Application number: 2019/90397	
What is the application for?:	Erection of front and rear single storey extension and dormers to side
Address of the site or building:	2, Squirrel Hall Drive, Dewsbury, WF13 4AH
Postcode:	WF13 4AH

PROPOSED GROUND FLOOR PLAN

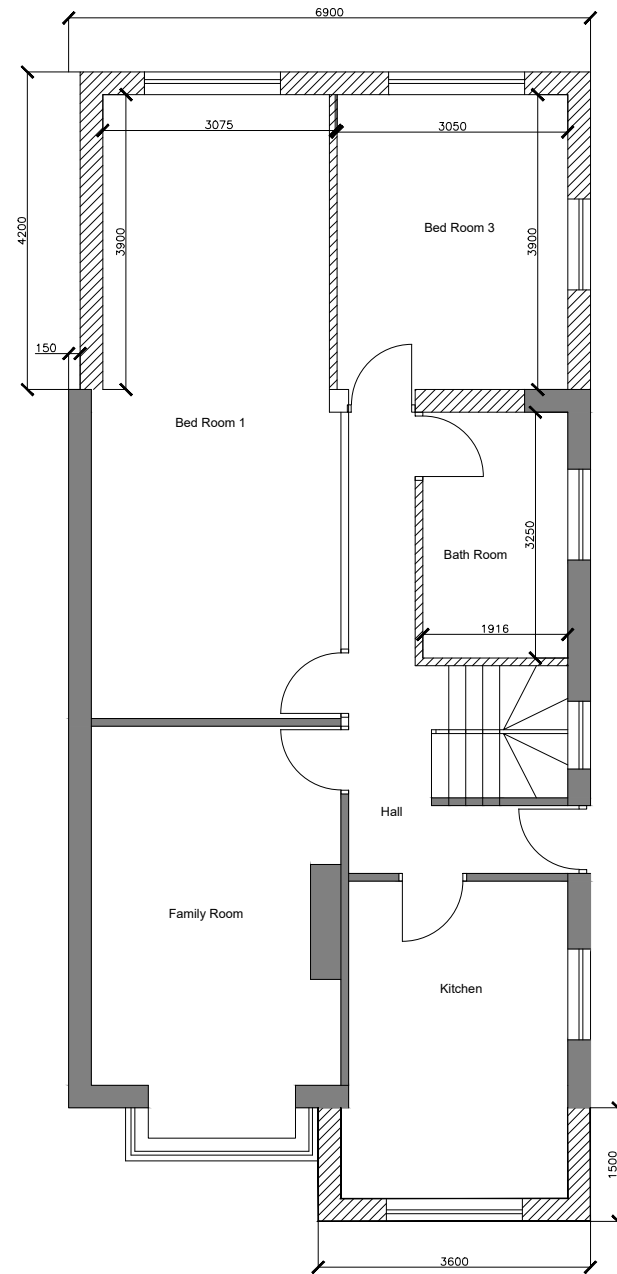
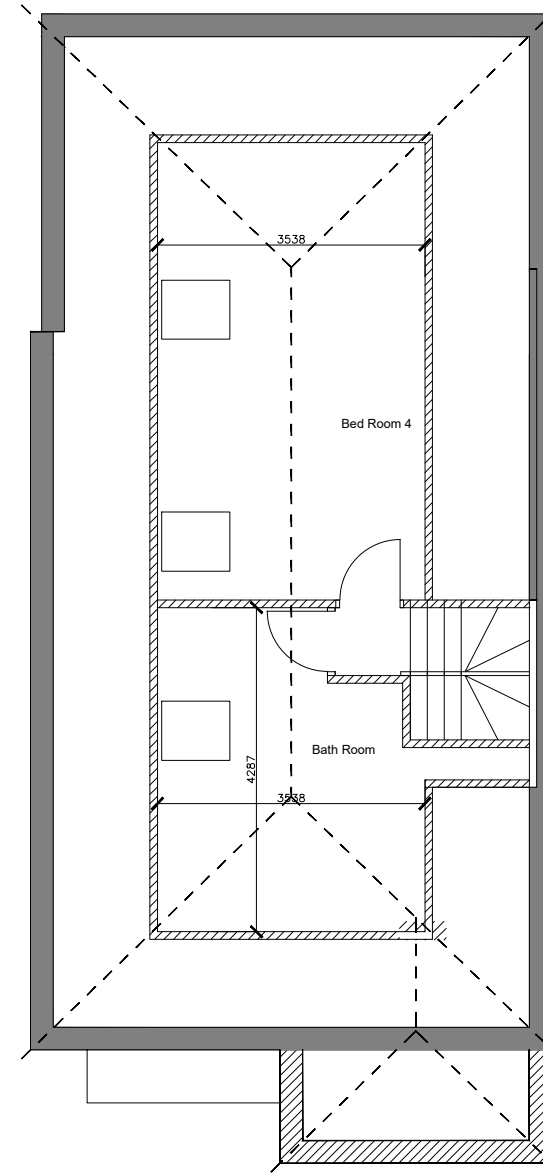
The scale and design of the proposed rear extension means that the rear windows will receive no natural light at all due to the edge and the west facing one will be inches from the side elevation of the existing garage.

Considering the prominent location of the property, along with the scale of the proposal the rear extension will form an incongruous feature within the existing street scene and will have an overbearing impact on the adjacent property.

The proposed dormers do not comply with the requirements of the UDP in regards to size and position. They are not constructed within the roof plane of the original structure and the roof no longer becomes the predominant feature.

The front wall of the dormers are not set back enough in relation to eaves/gutter line. This means that they are too large in scale for both the host property and the surrounding roofscape.

With the proposed dormers being on the side elevation and of such a scale when viewed from the street the roof will not be symmetrical, the hip to the east elevation will effectively disappear visually, being replaced with the square dormer stretching from the eaves to the ridge.
